AW/91/13 – 22 The Drive – front wall – 14-6-2013

FURTHER OBJECTION: Proposed front wall and gates – 22 The Drive –
AW/91/13
within the Craigweil House Conservation Area AND Area of Special Character

PLAN NO 630|3

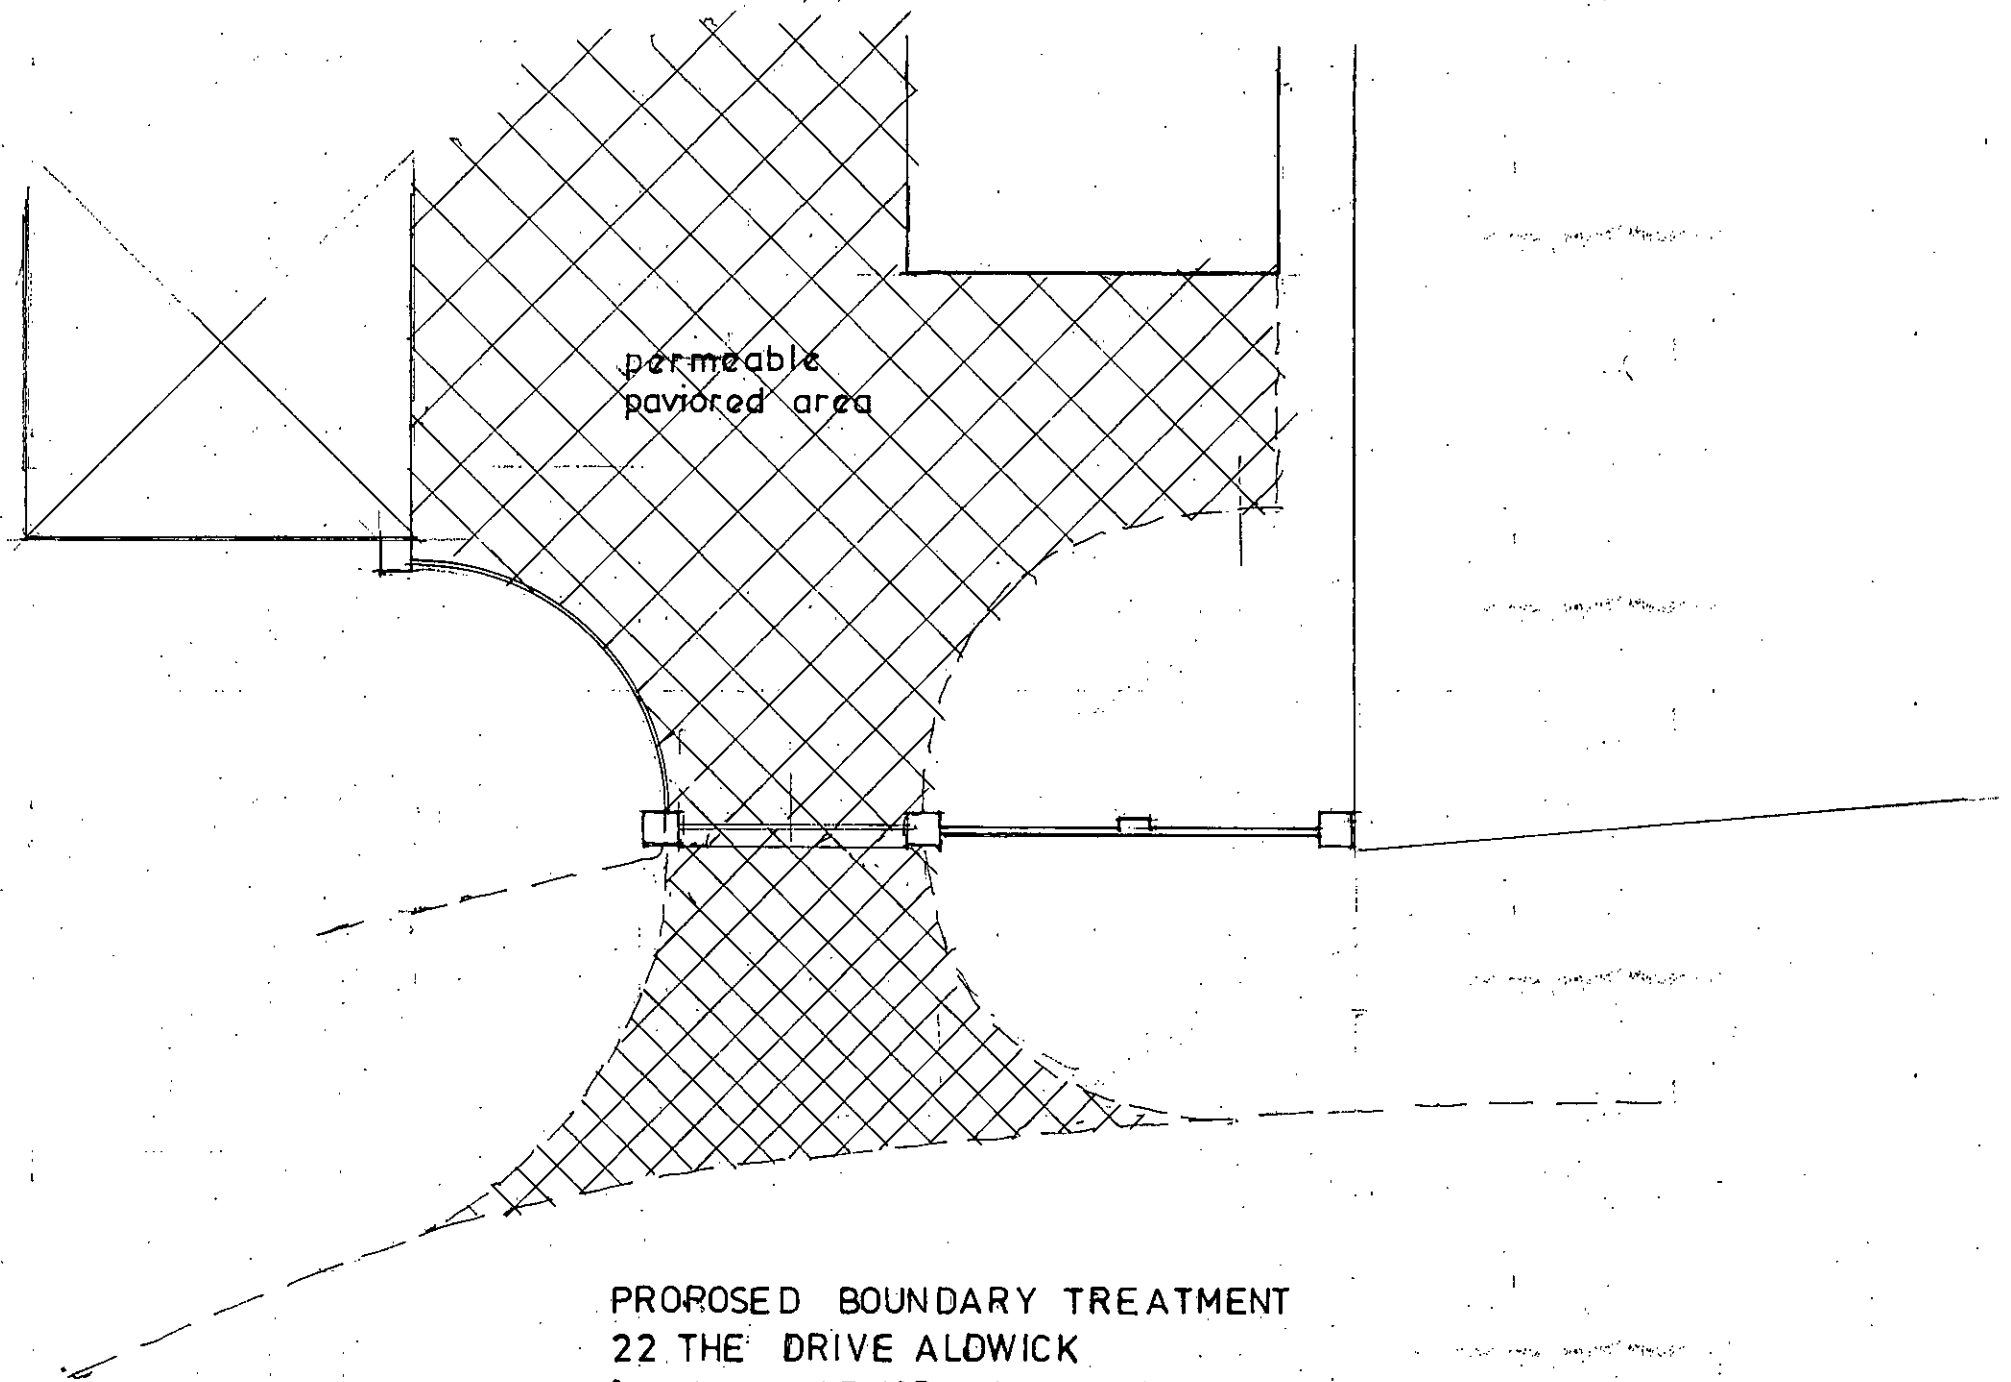
Mr. Brookman has no Arboriculturalist qualifications and claims no such knowledge or experience and says, in his brief letter 'I attach my tree survey'. We think this is not an acceptable Tree Survey to the standard required by BS 5837:2012. It does not even address those matters laid down in the BS – it is a rough sketch plan!

We note that it shows the area from the proposed gate and walls as '*Permeable pavioured area*' but there is no application for this and the area is graveled with 20mm shingle that is appropriate and accords with the original, and still extensively existing, finish for driveways. **There is no existing 'permeable pavioured area'!**

Ref No. 4929

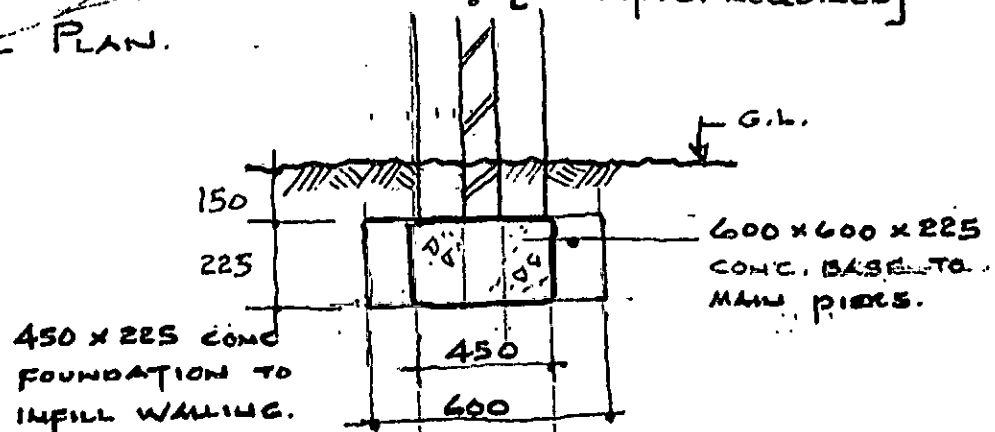
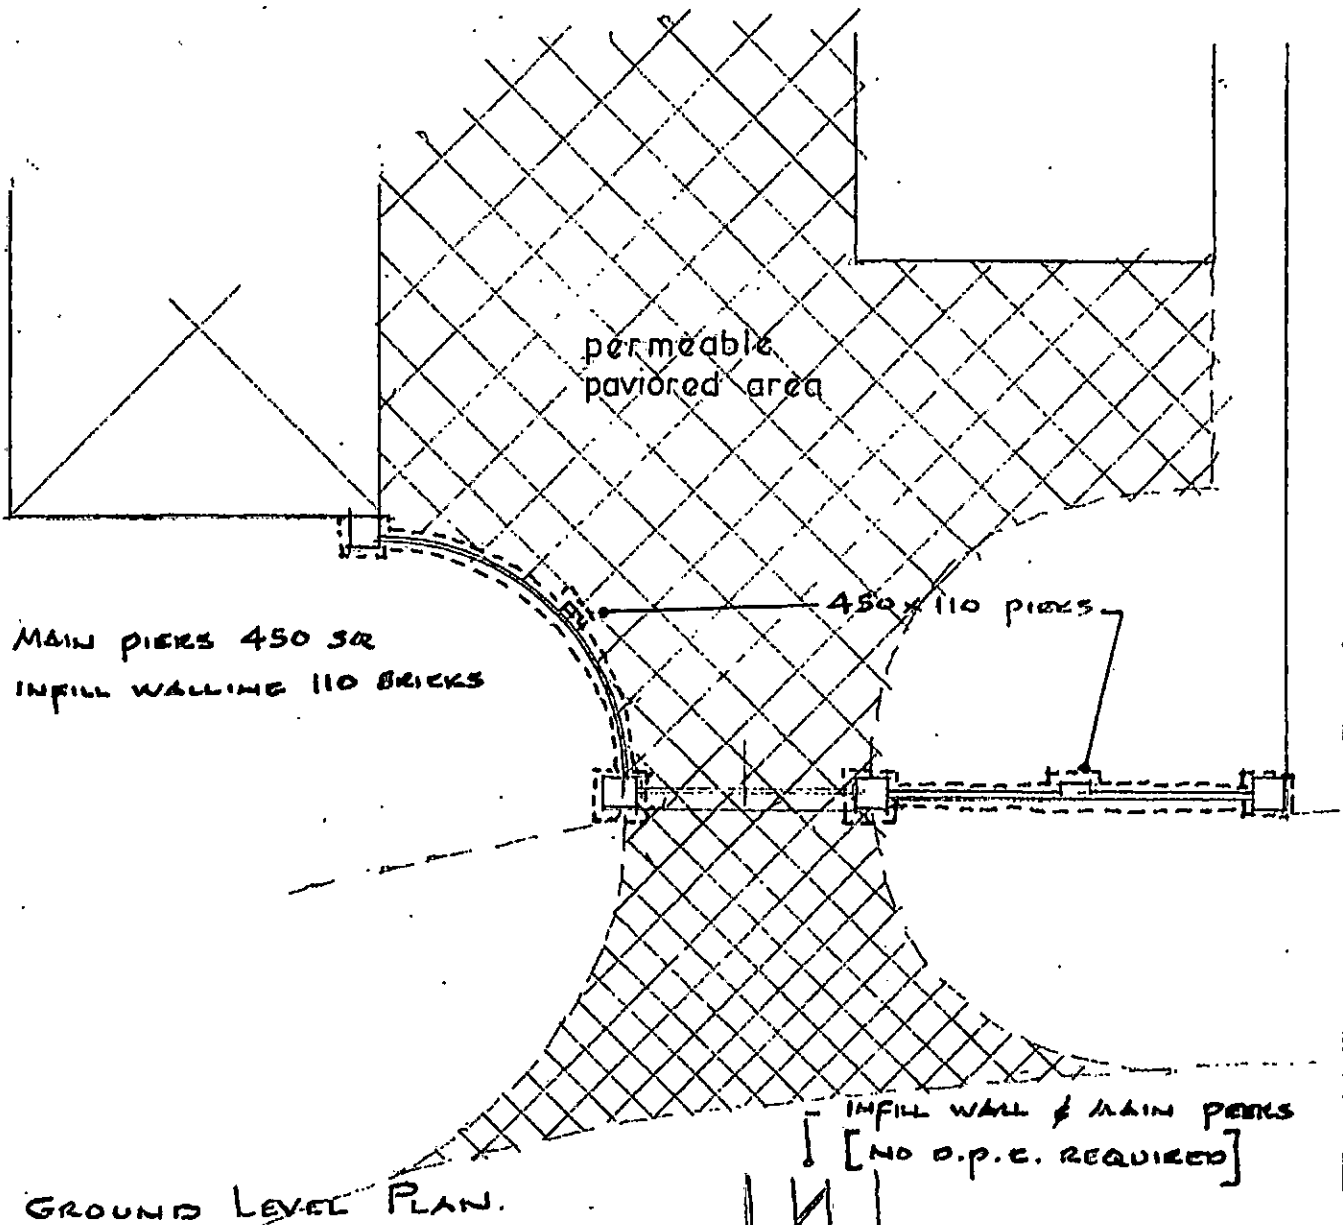
The hand drawn section on the Hilton plan shows a section of *the 'foundation to infill walling'* which is capable of any translation but appears to show a total depth of 1.425m. From 'G.L.' – presumably ground level - there is 150 (presumably mm) of something undisclosed, followed by 225mm, then 450mm of something and 600mm of something – presumably we have to assume or guess what is this construction for it is not stated. We find this unsatisfactory and unacceptable for to accept this plan is to accept the unknown and issue, if granted, a licence to place anything. *Again, 'permeable pavioured area' is marked when it is a 20mm gravel covered driveway – probably over tarmac.*

We stress again that the tree feeder roots (BS5837:2012) are mostly in the top 600mm of the soil and spreading outwards on the perimeter of the tree. *Where roots encounter short driveways, as existing here, they will travel UNDER that – and possibly the brick block roadway also – in their search to find free ground and to draw in AIR, WATER AND NUTRIMENTS for survival.* PARTICULARLY in older trees, to damage these roots will be to seriously harm or kill a tree – the Oak here is the most vulnerable and already has very little grass area around it to survive.

To place these footings, as shown, will be to cut off ALL FEEDER ROOTS – no matter whether or not they are HAND DUG – for no less than 200 degrees of the circumference of that tree and less than 2m from the trunk when the area 12 times its diameter (BS5837: 2012) should NOT be disturbed but fenced off before building and remain untouched and regarded as sacrosanct.
